Application for a Non-Material Amendment Following a Grant of Planning Permission

2023/0986/FUL

PROPOSED SIDE ELEVATION

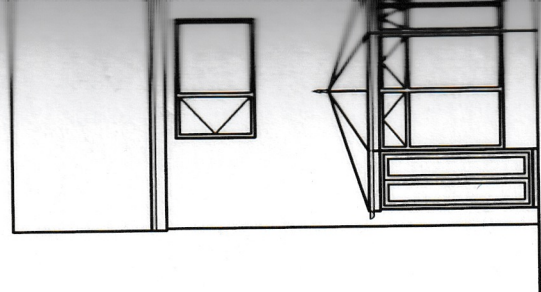
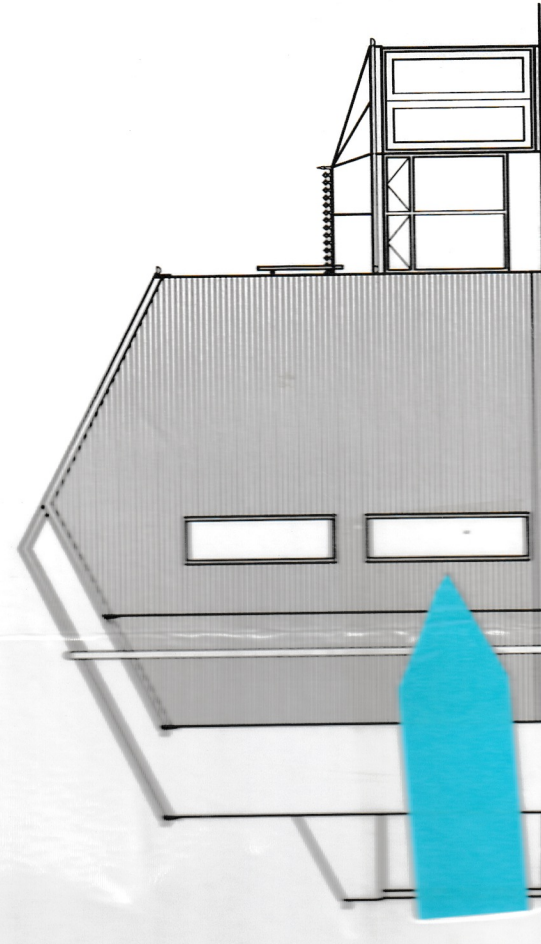
The original design did not allow for the ground floor window to be opened. Also, I was informed that the size of the window, i.e. the height, was beyond the limits of the manufacturer.

The previous plans showed two single windows on the side elevation. This amendment is to allow for each of the windows to consist of two windows.
